A46 Newark Bypass

TR010065

7.52 Applicant's Summary of the Issue Specific Hearing 4 (ISH4)

Issue Specific Hearing 4: Environmental Matters – 5 December 2024

Drawing file: TR010065 / TR010065-000174-TR010065_A46 Newark Bypass_6.2 Figure 8.4 - Planting for Loss of Local Wildlife Site Habitats.pdf

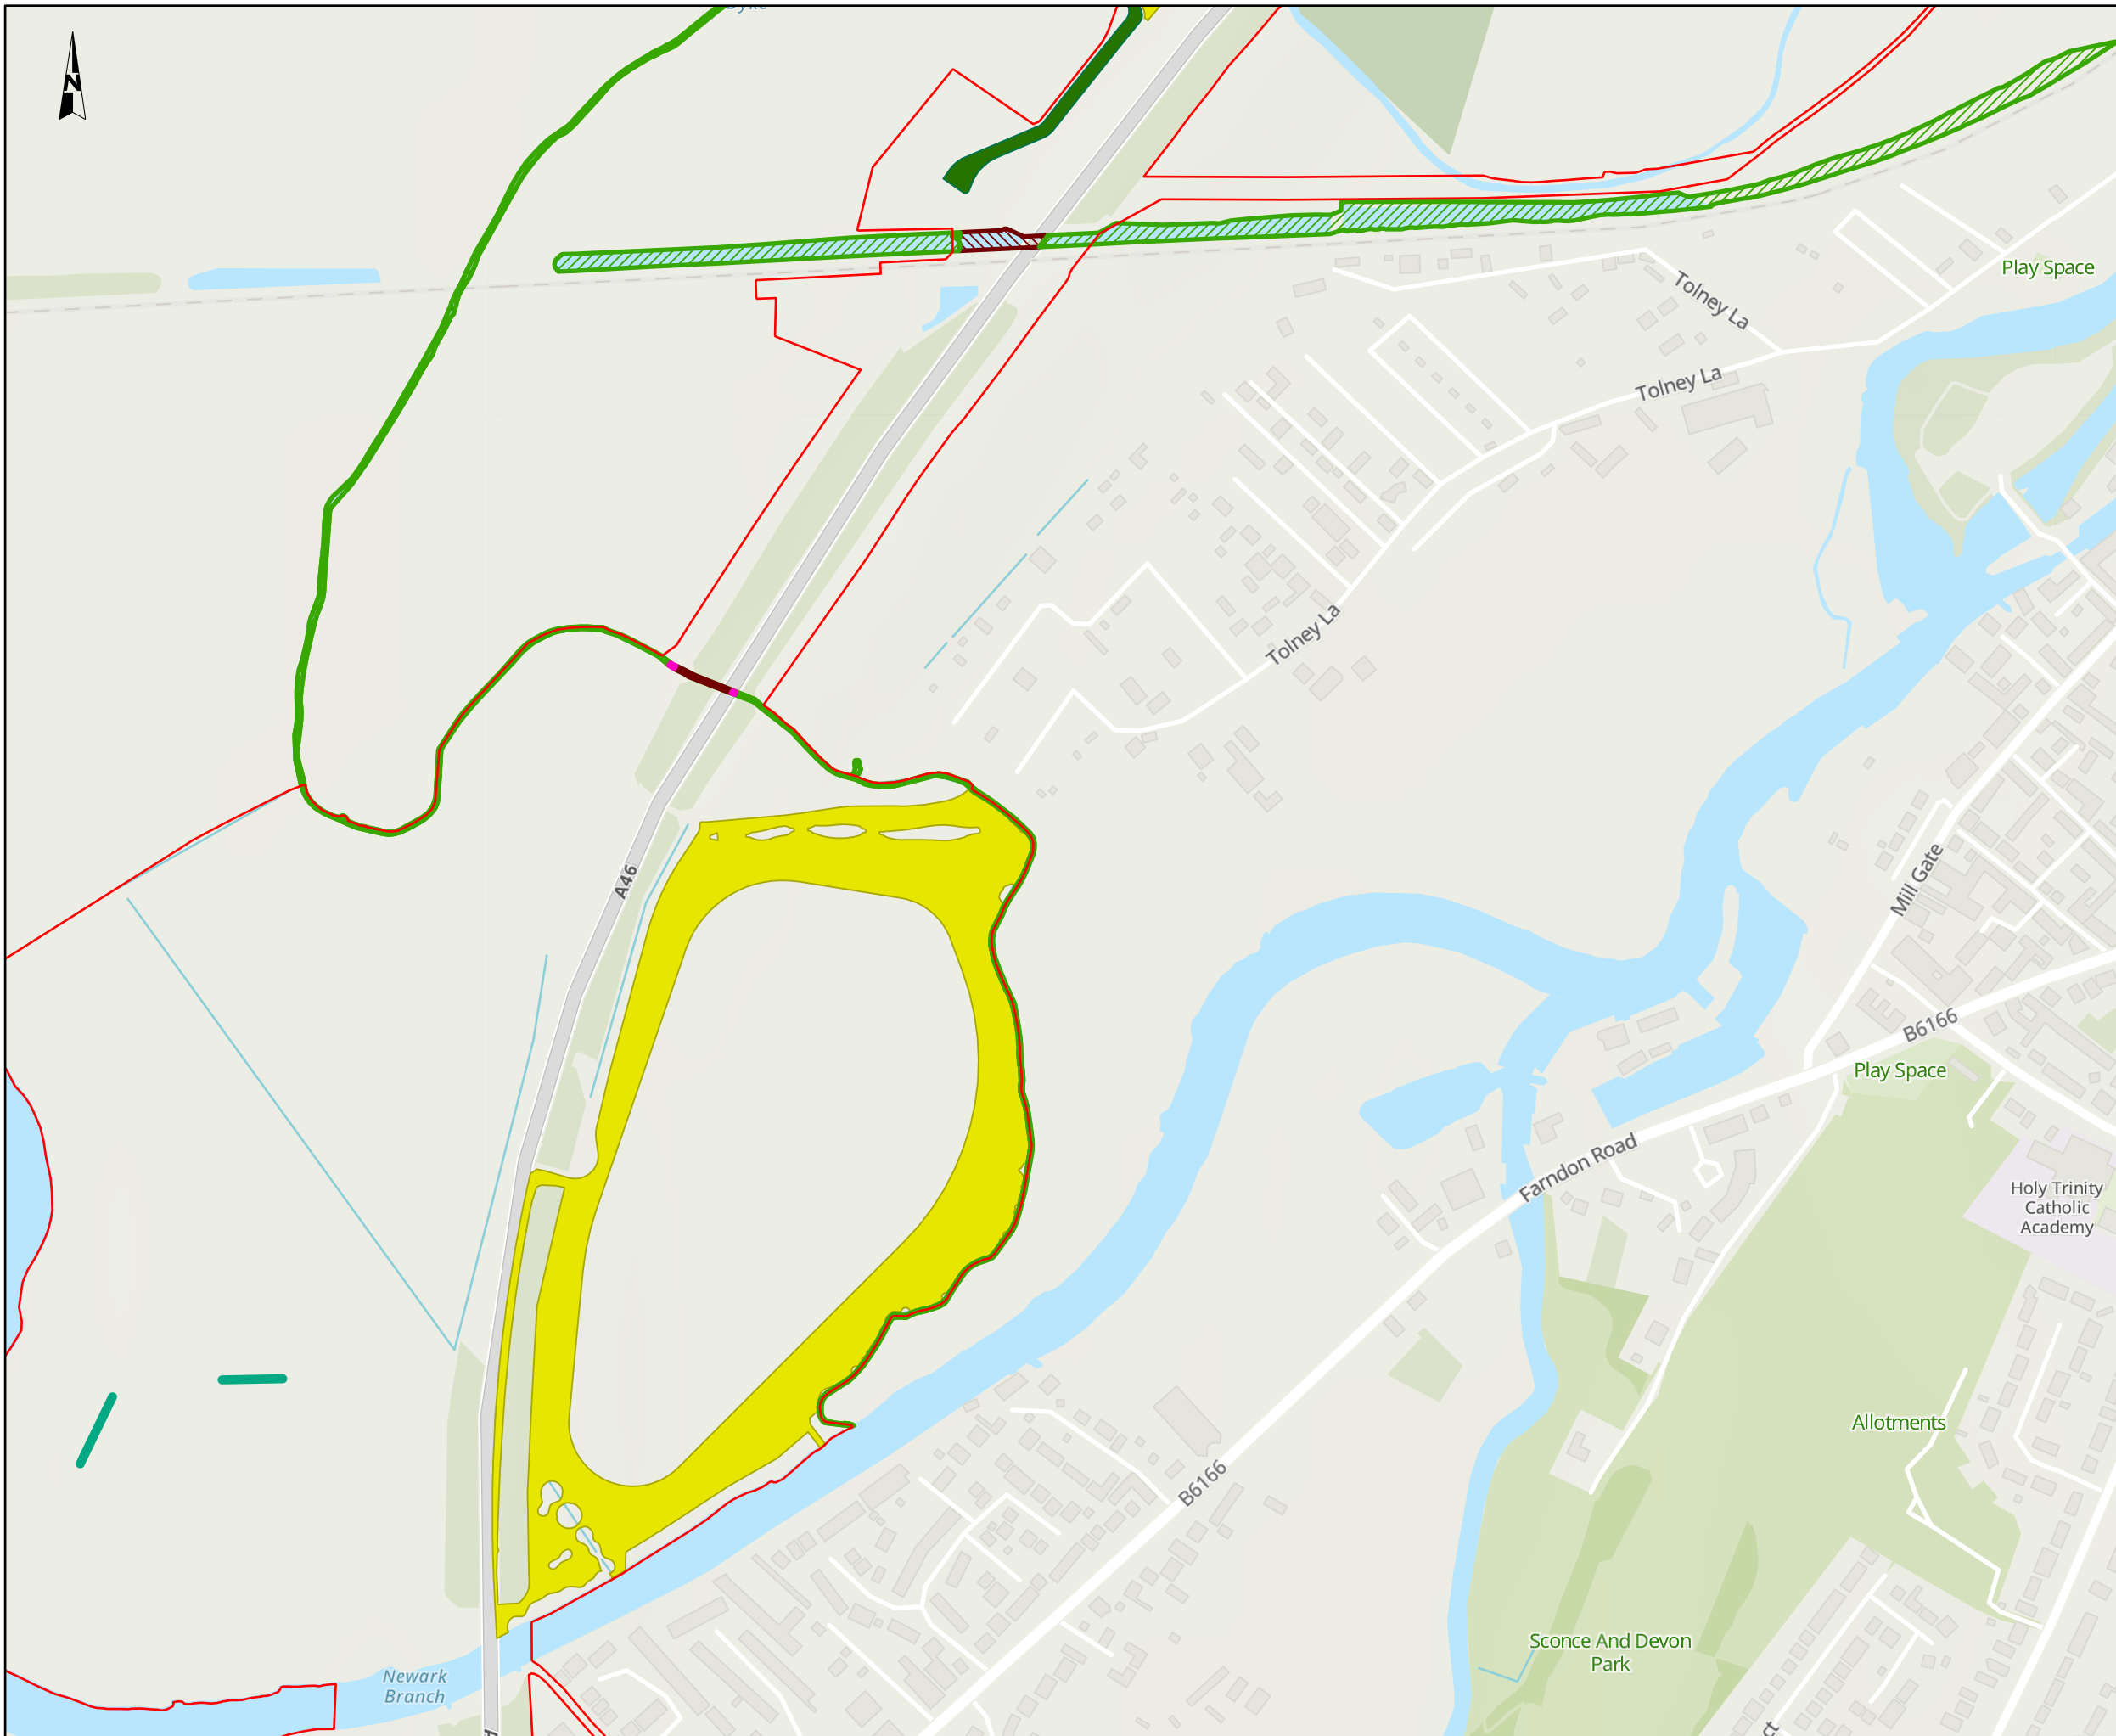
3.1.4	ExA	The ExA asked for clarification on where the areas of temporary loss were shown on ES - Figure 8.4 – Compensation Planting for Loss of Local Wildlife Site Habitats [AS-045]	The Applicant confirmed that the area of temporary loss on page 4 of Figure 8.4 of the ES (Compensation Planting for Loss of Local Wildlife Site Habitats) is shown in the vicinity of Old Trent Dyke, highlighted in pink, which is an area of Old Trent Dyke LWS which is subject to temporary possession.
